## **Application by Roxhill (Junction 15) Limited for a Development Consent Order for the Northampton Gateway Strategic Rail Freight Interchange**

### **The Examining Authority's written questions and requests for information (ExQ1)**

**Issued on 17 October 2018**

**FIGURE 4.1**

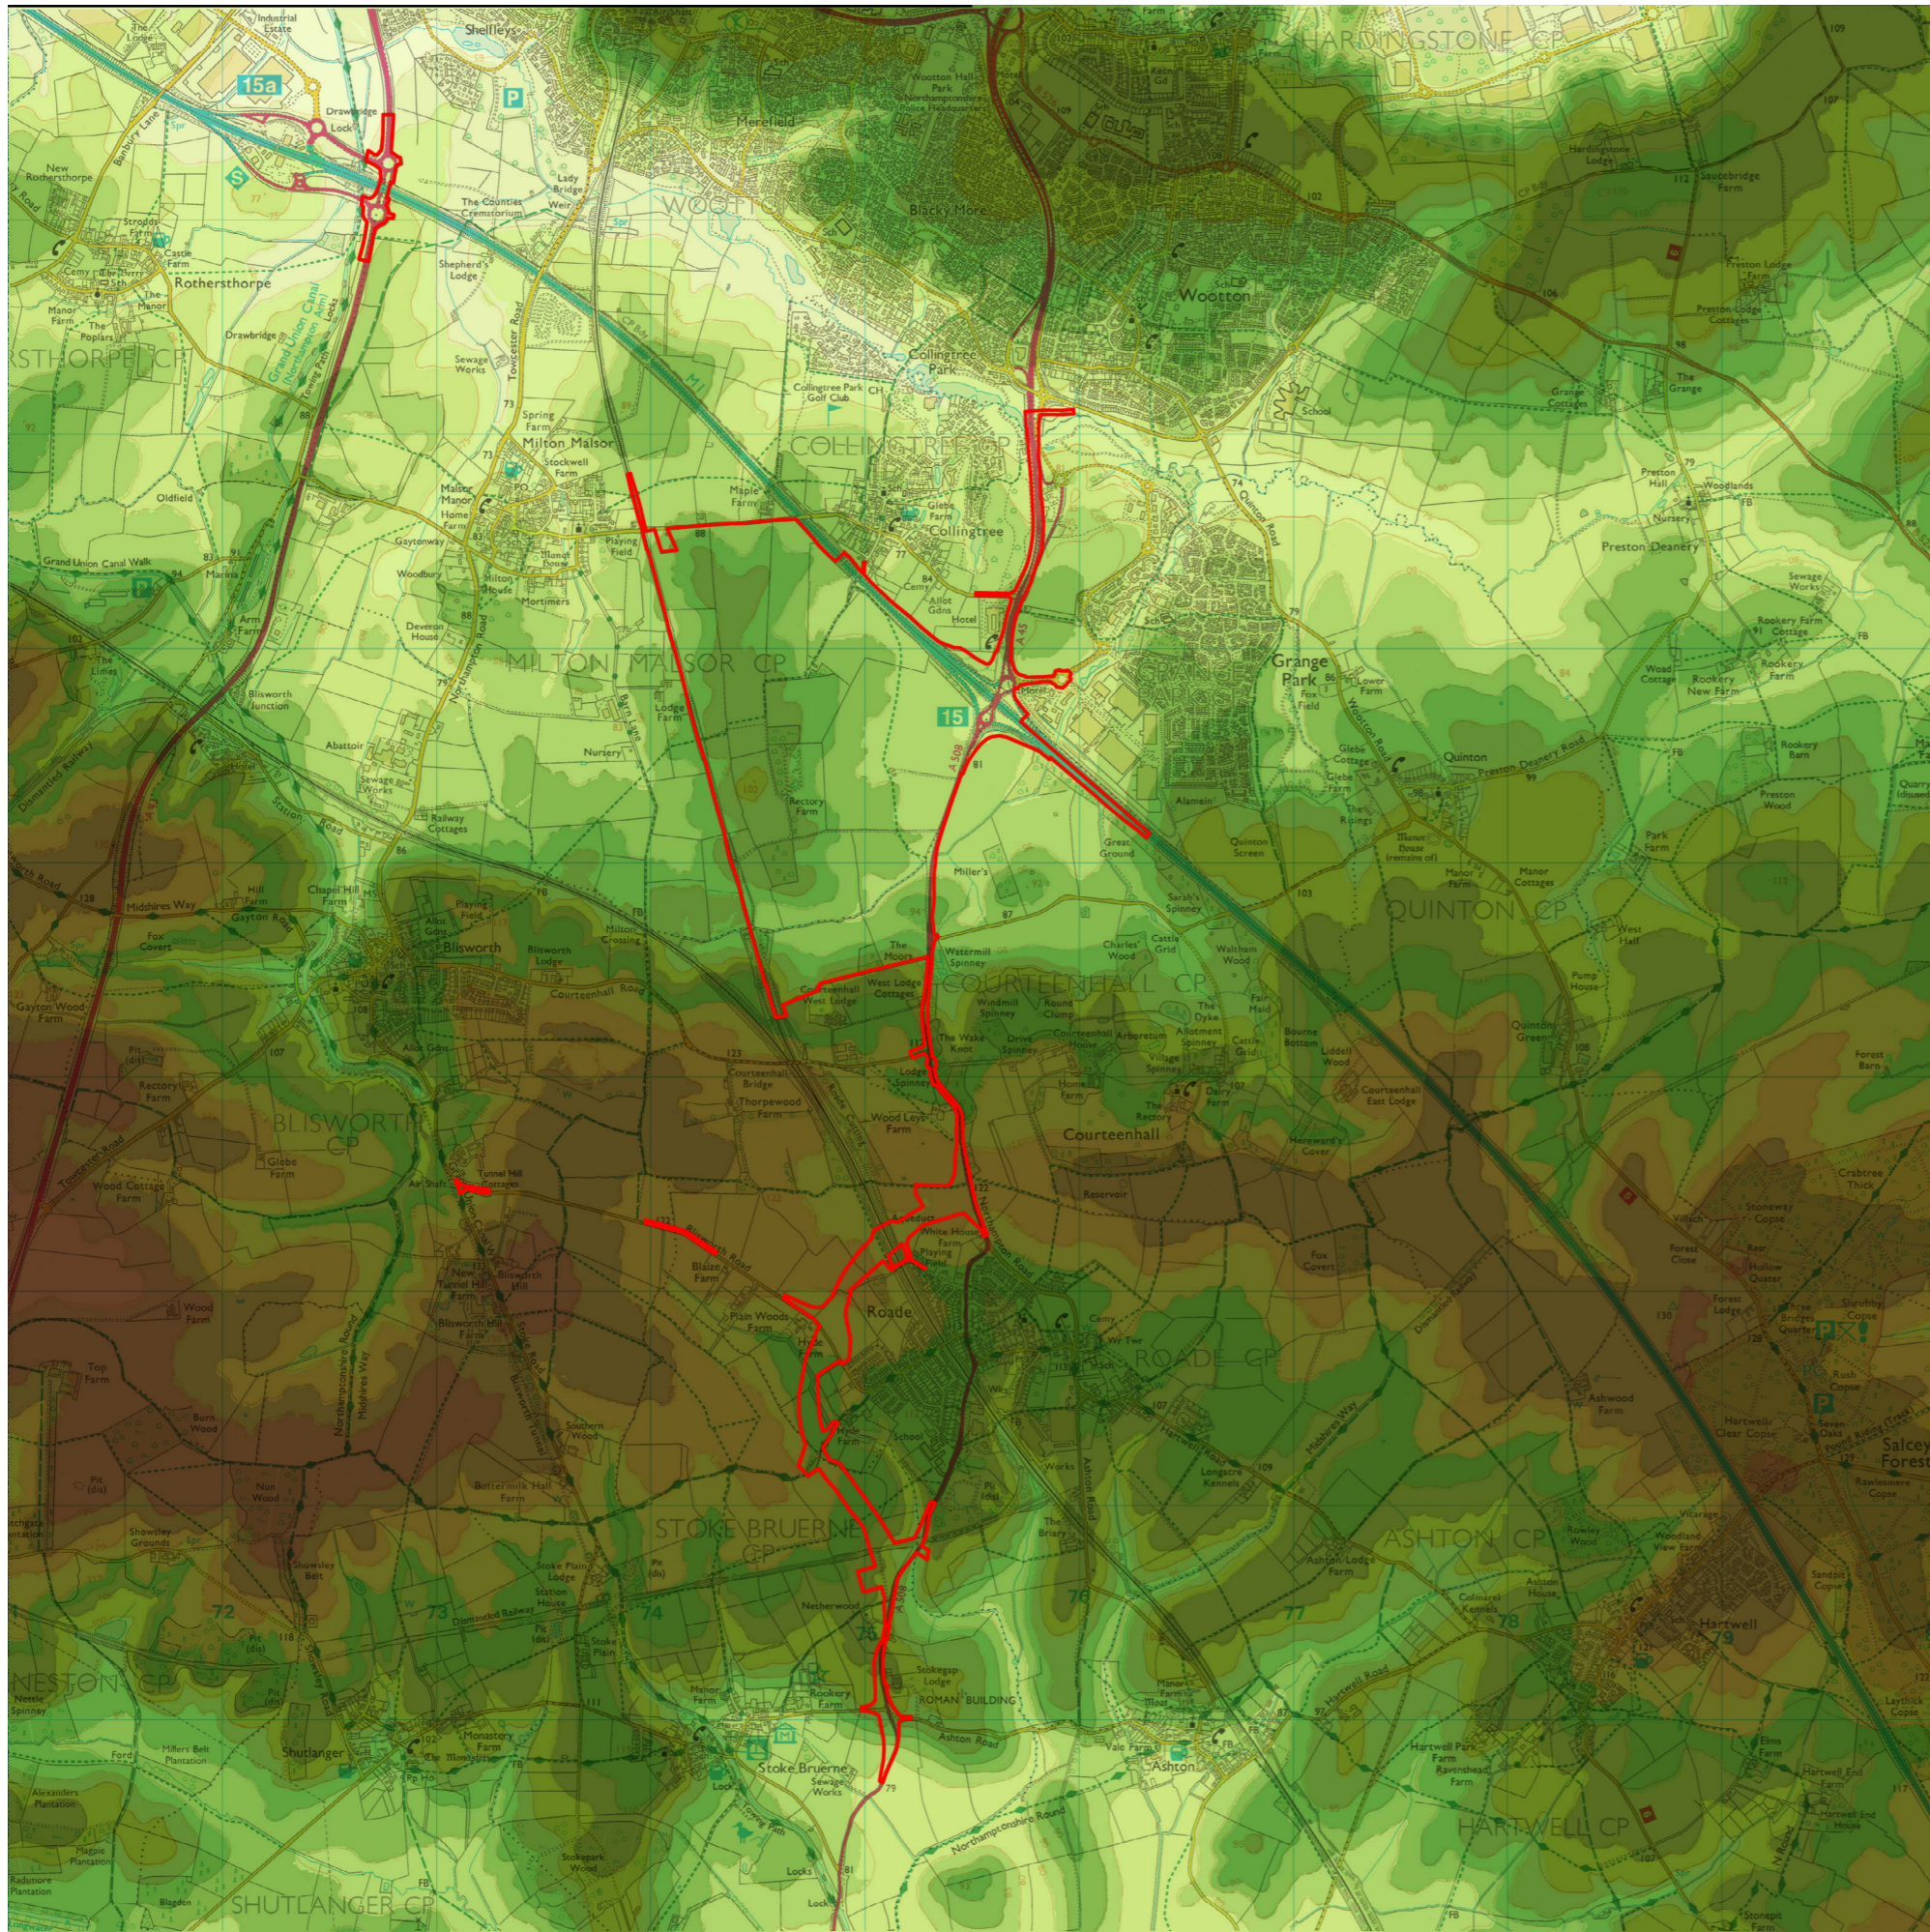
1.0.9	The Applicant, SNDC	ES Chapter 4 (Landscape and Visual Impact) Figure 4.1 [APP-085] shows a substantial portion of the main site of the Proposed Development falling within an 'Area of Important Local Gap' to which saved Policy EV8 of the South Northamptonshire Local Plan applies. This policy seeks to prevent development that would significantly intrude into this gap. Please comment on the significance of the apparent conflict with this policy.
